Located At 56 HAMMOND ST

Job ID: 2012-06-4359-CH OF USE

has permission to Demo existing structure, build new 3 story, 3 unit apt., 1 of 2 on Parcel B, single exit enclosure provided that the person or persons, firm or corporation accepting this permit shall comply with all of the provisions of the Statues of Maine and of the Ordinances of the City of Portland regulating the construction, maintenance and use of the buildings and structures, and of the application on file in the department.

**Jeanie Bourke - RE: 56 Hammond St BP#2012-06-4358 & 4359 plan review comments**

**A101**  
PERMIT SET  
5/18/2012

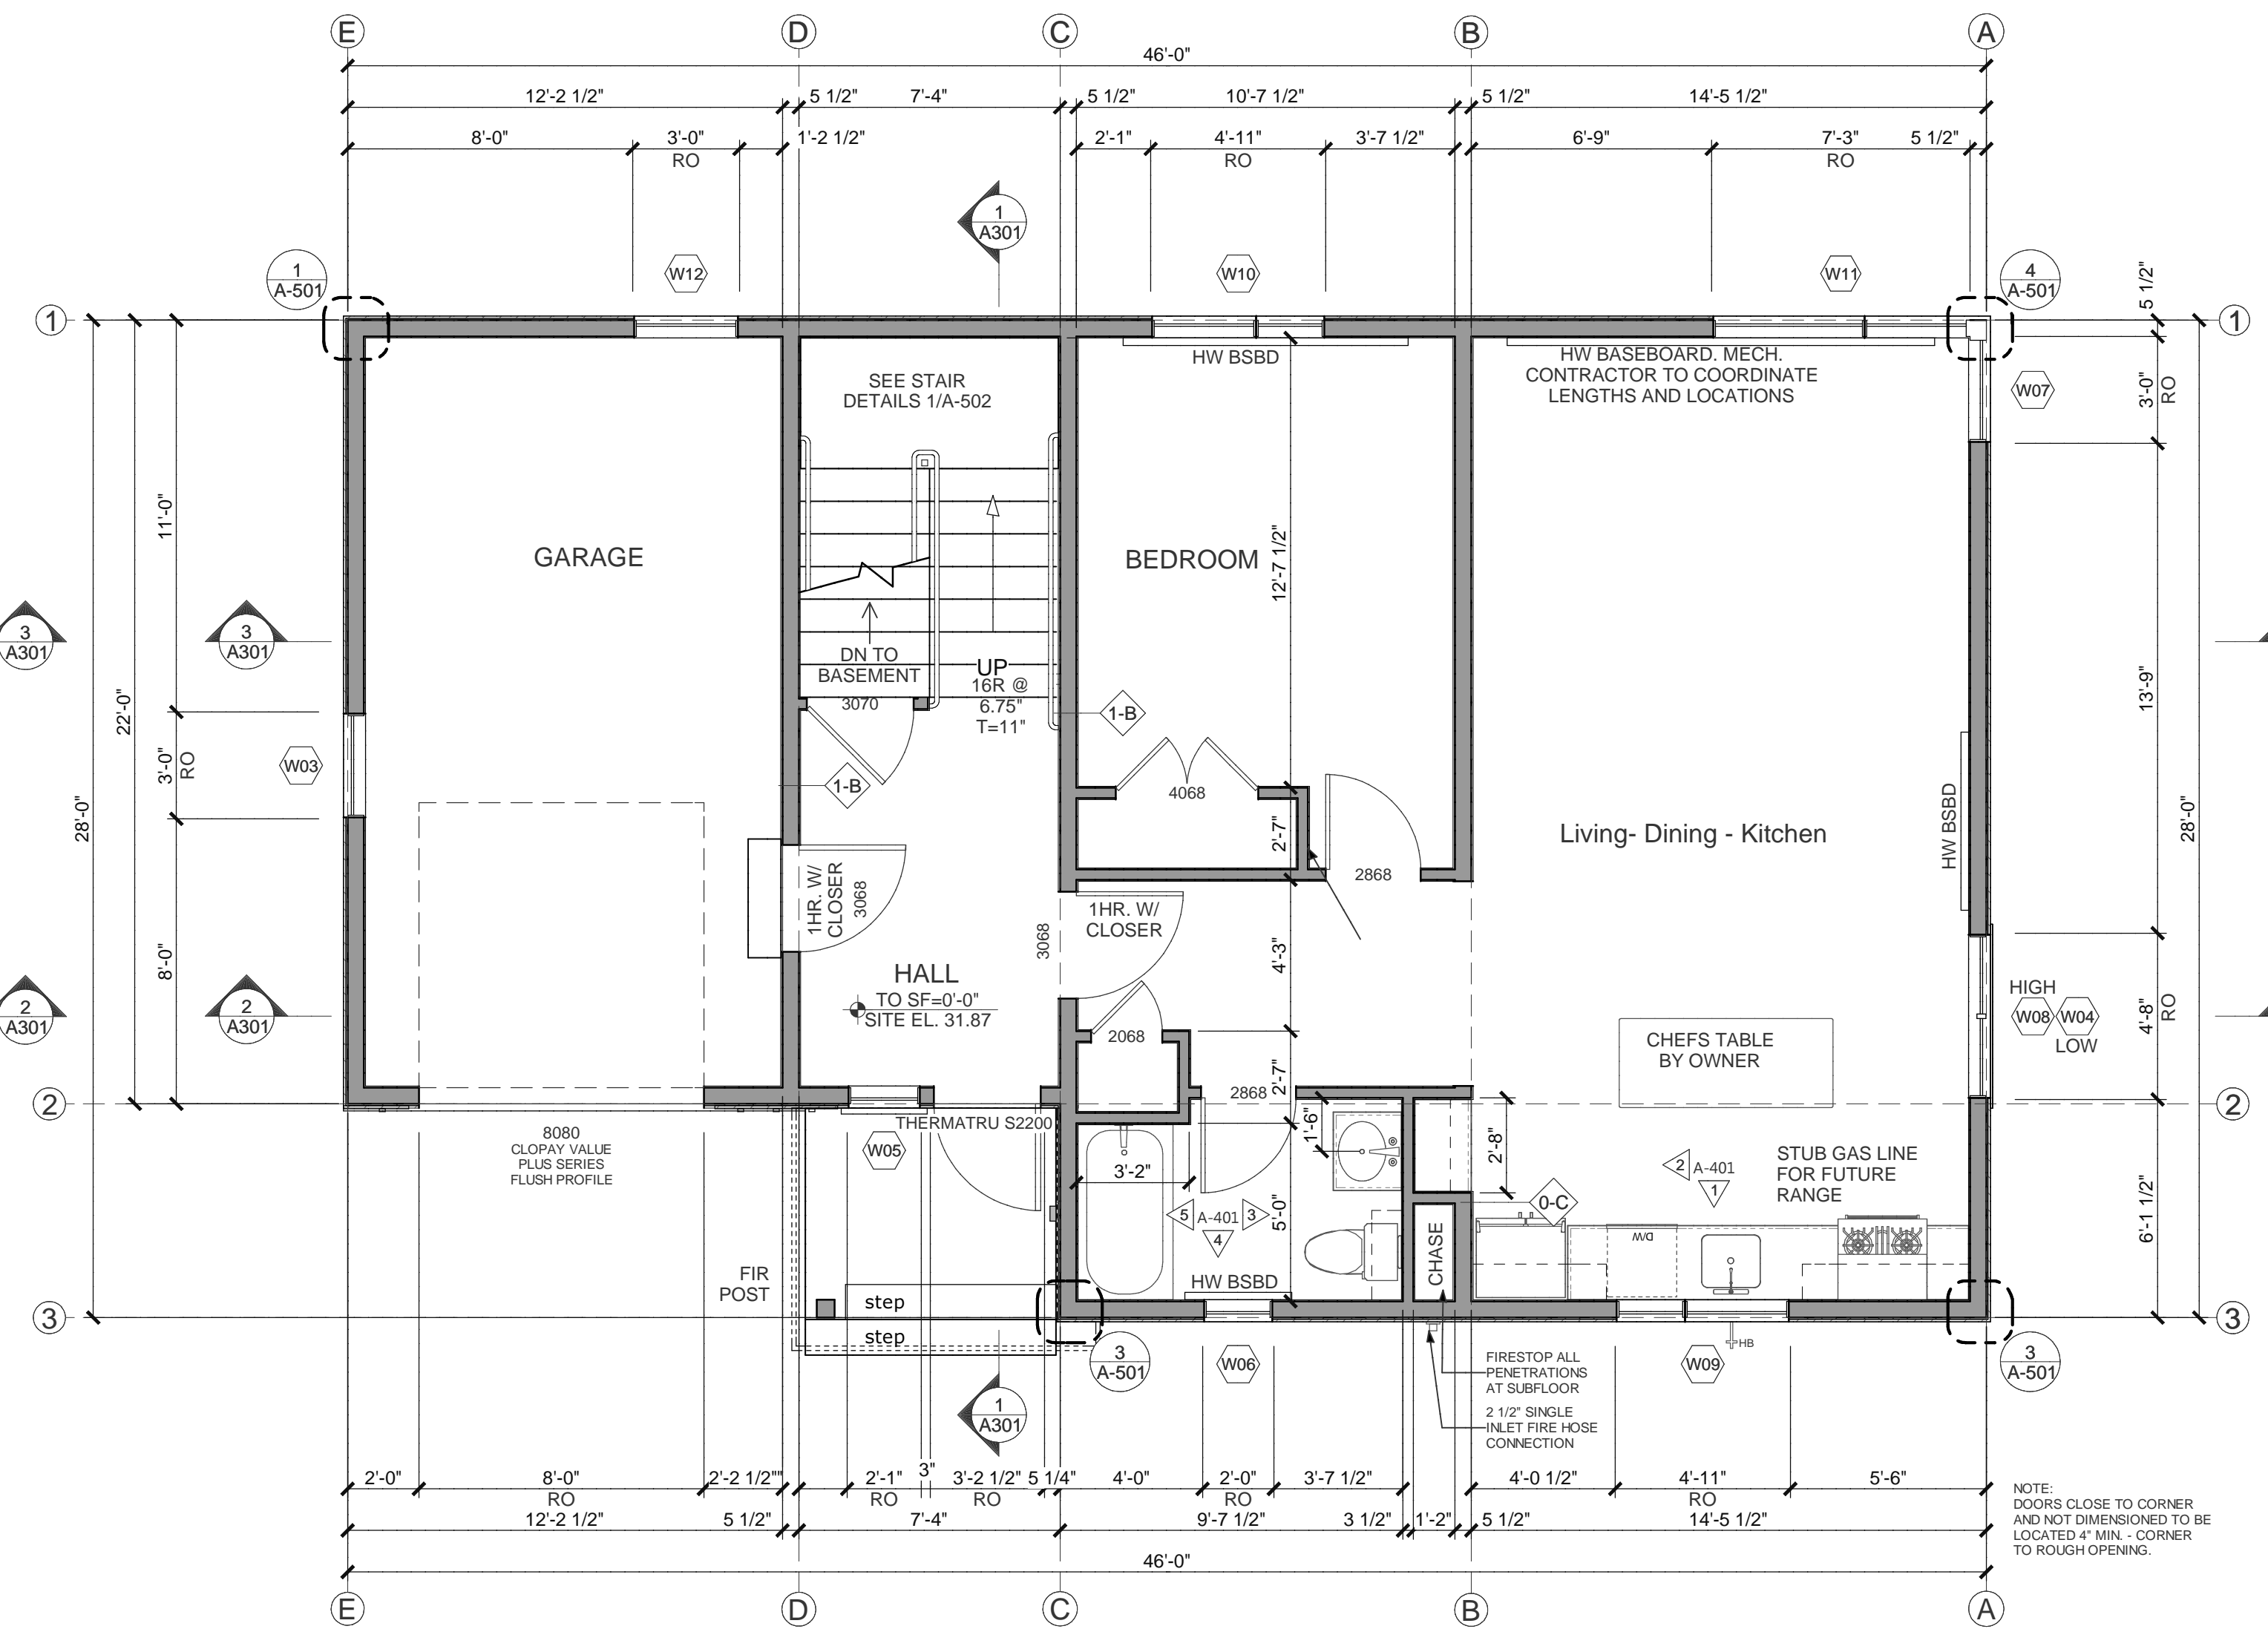
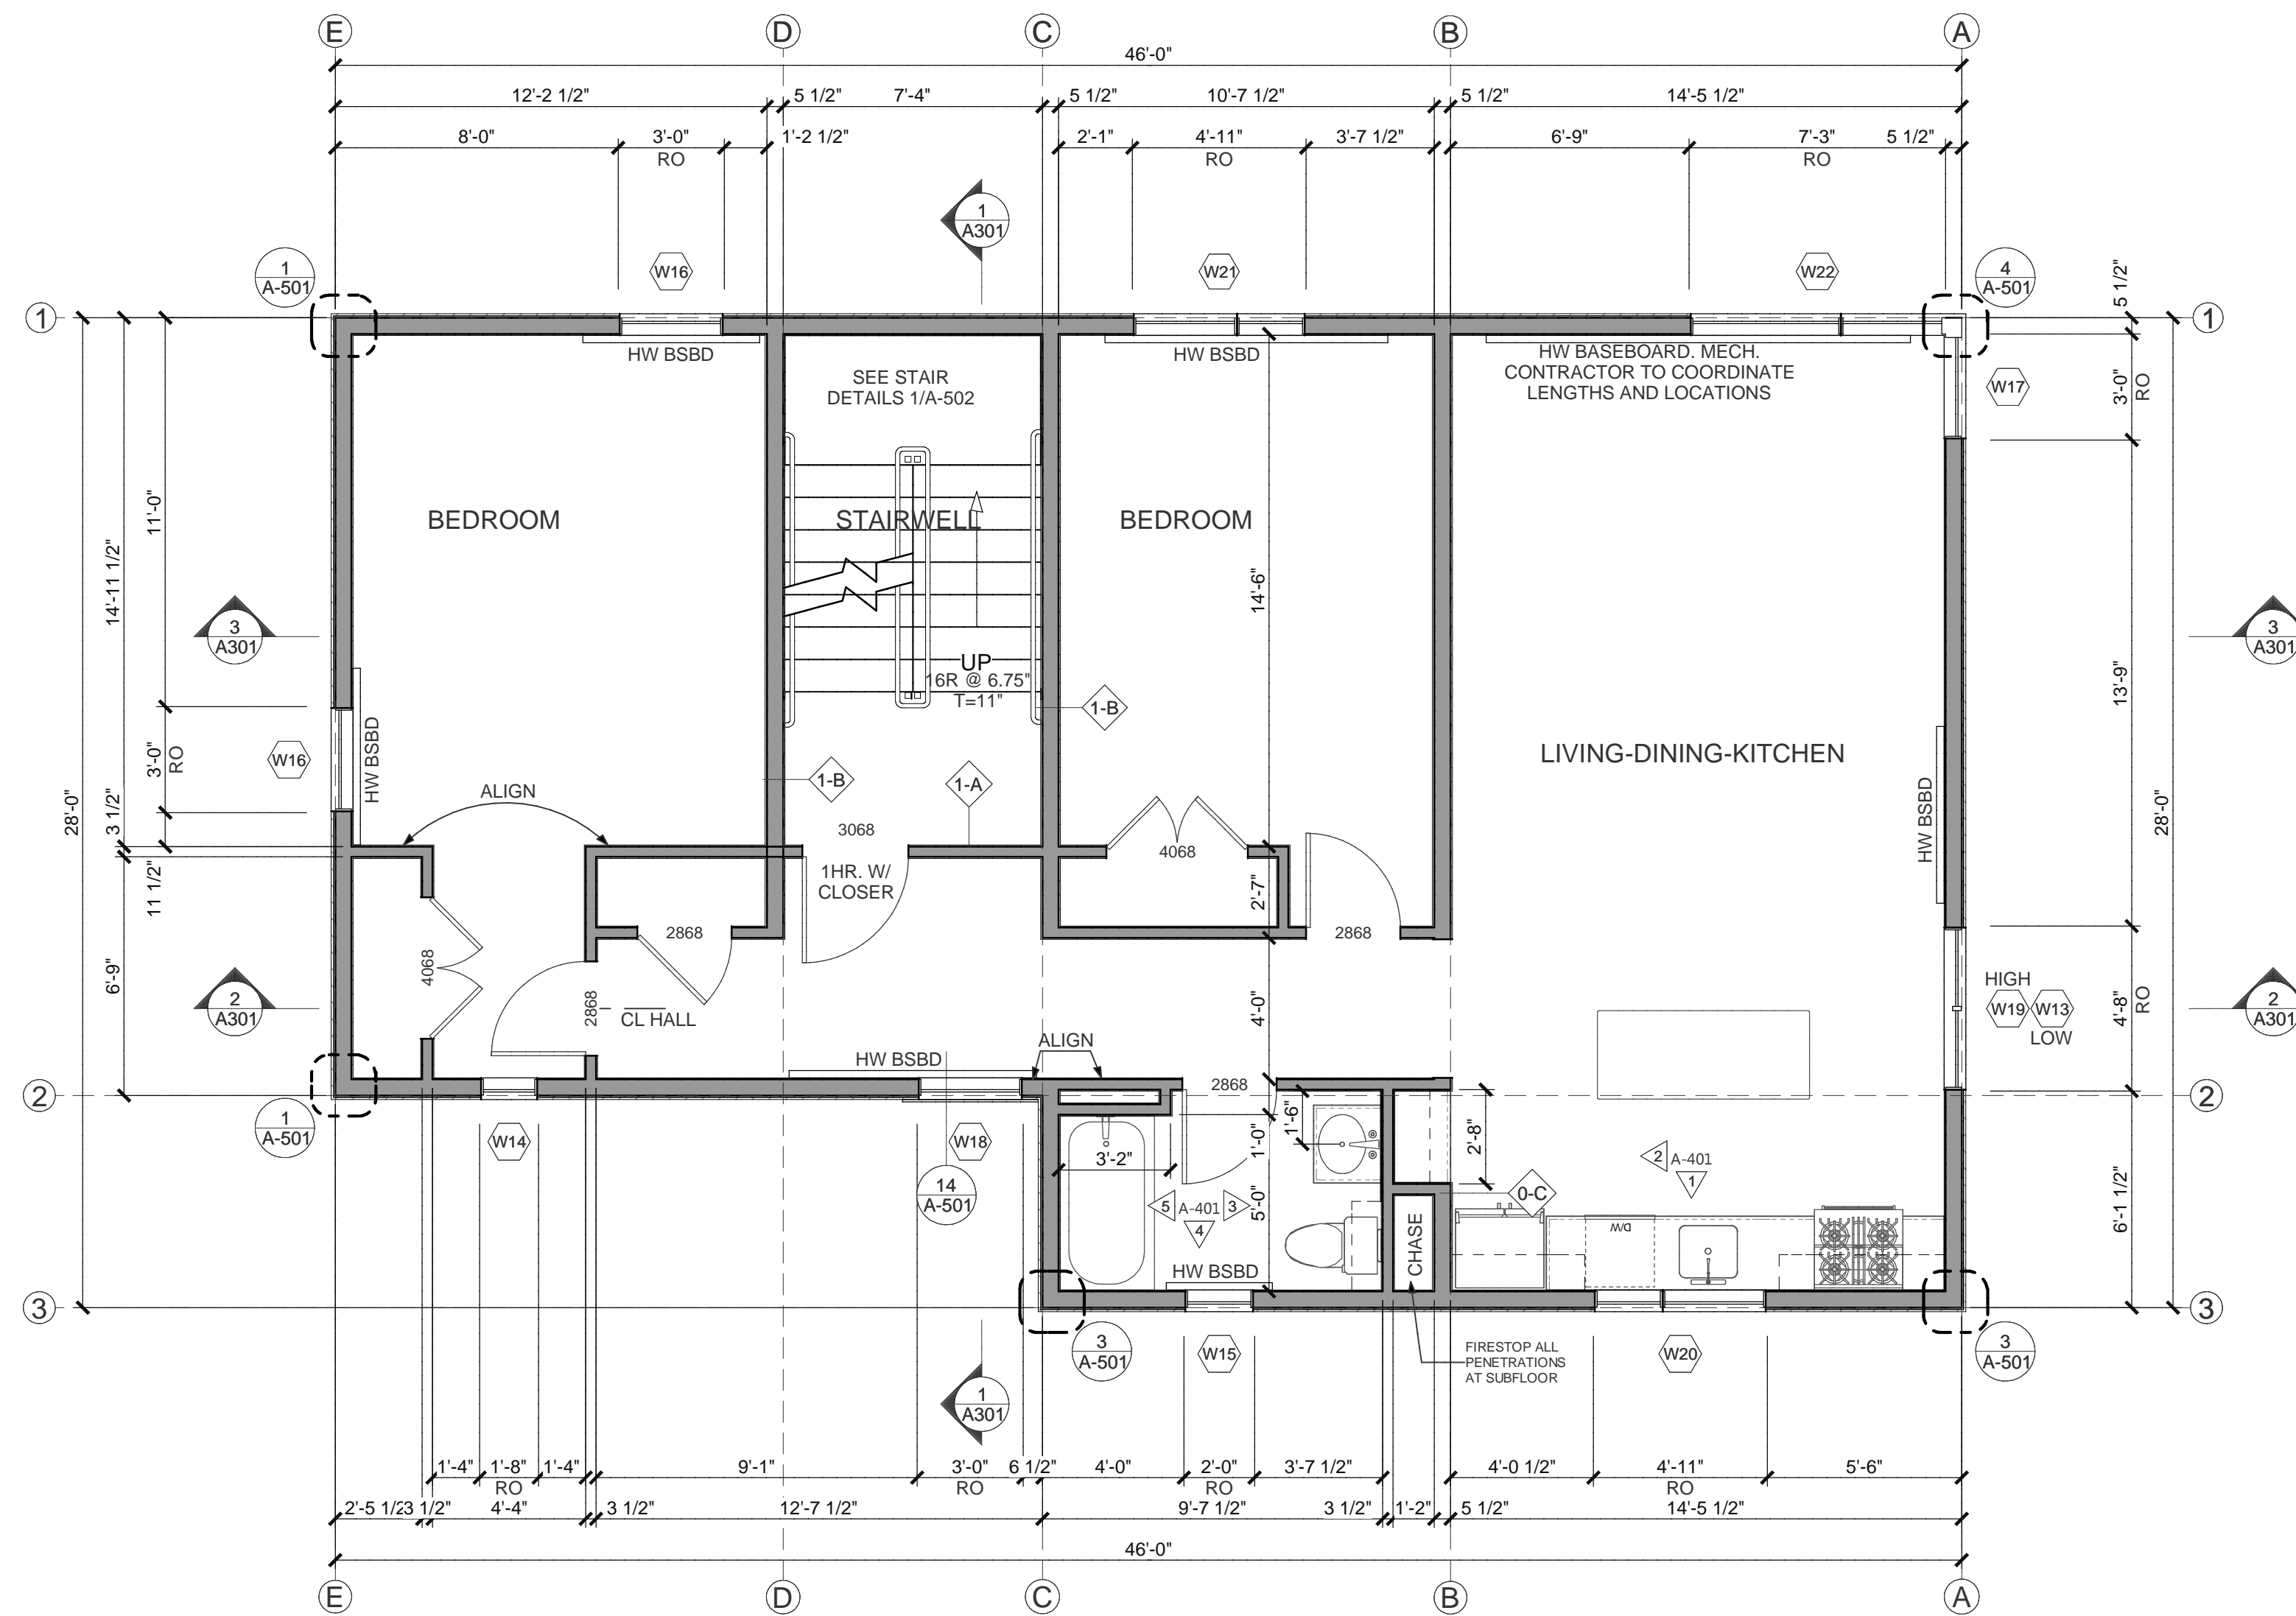
· Provide a 1 hour rated wall assembly for the mechanical chase 0-C or clarify if the penetrations are individual and sealed at each floor, thus not a true chase enclosure

*The penetrations are sealed at each floor. That is the intention of the note "FIRESTOP ALL PENETRATIONS AT SUBFLOOR" included on sheets A101 & A102.*
